**Memorandum
ABP-320946-24 –
Request for Further
Information**

To: Una Crosse, ADP
From: Hugh O'Neill, SPI
Re: 320946-24 – Request for Further Information
Date: 18th November 2024

Date: AUGUST 2024
Scale: 1/500 @ A1
Drawing No: 24143-01

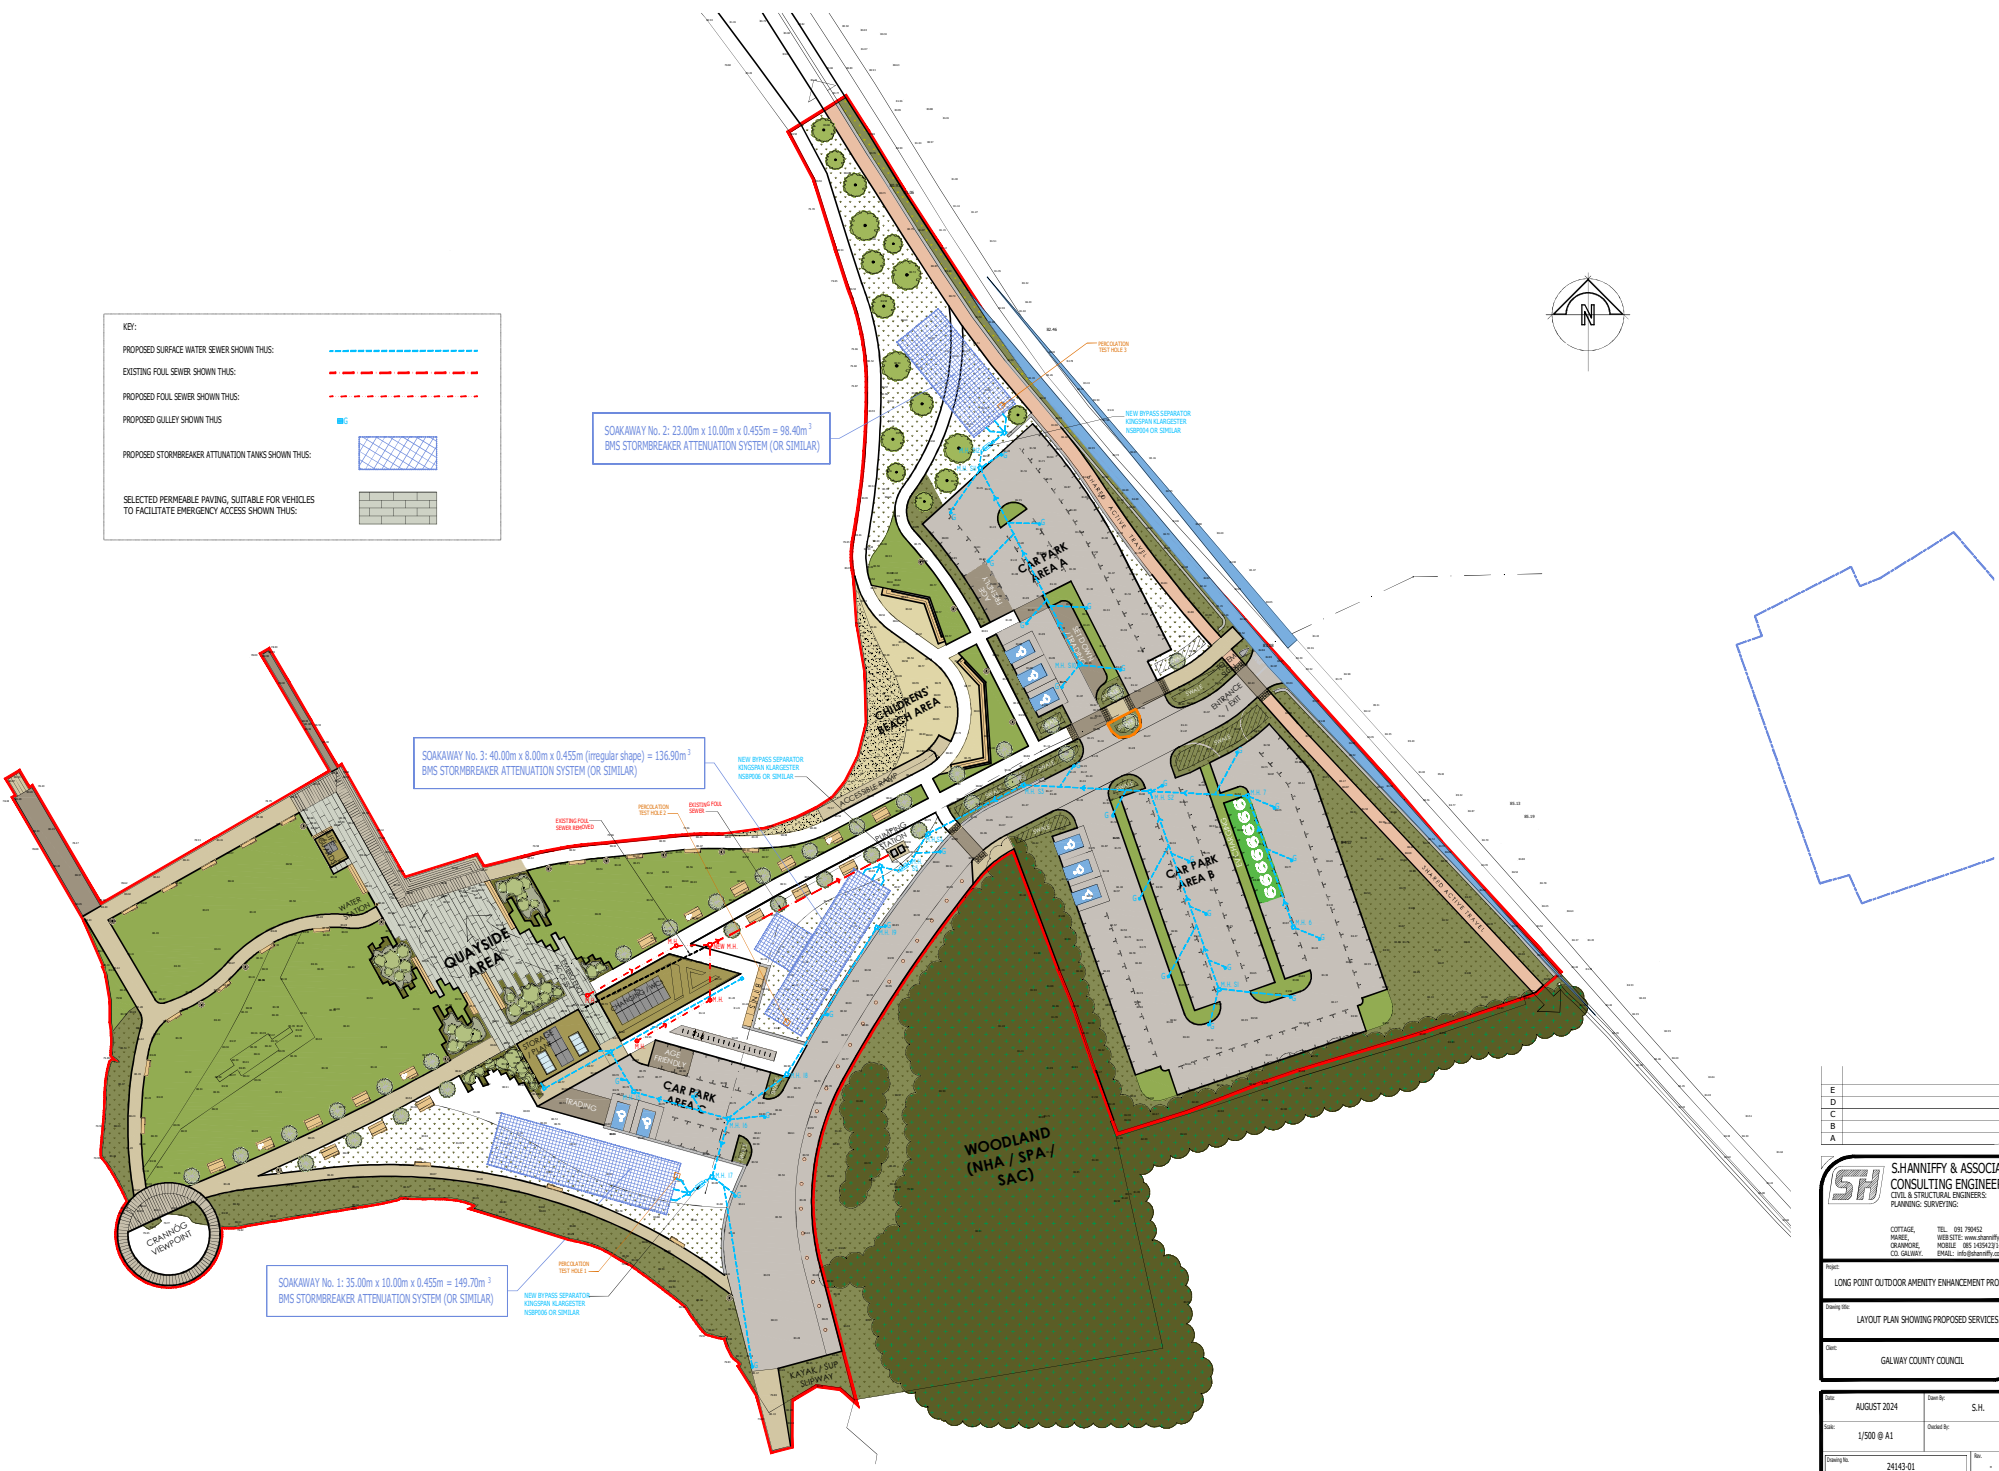
The Applicant shall provide further information to describe how flood protection of the foul holding tank and pumping station as recommended in the conclusion of the submitted flood risk assessment report has been incorporated into the proposal.

Further information is required in the form of clear drawings/sections demonstrating proposed site levels with reference to the proposed chamber levels of bypass separators and silt traps. This shall demonstrate how these structures are incorporated into the landscaping plan.
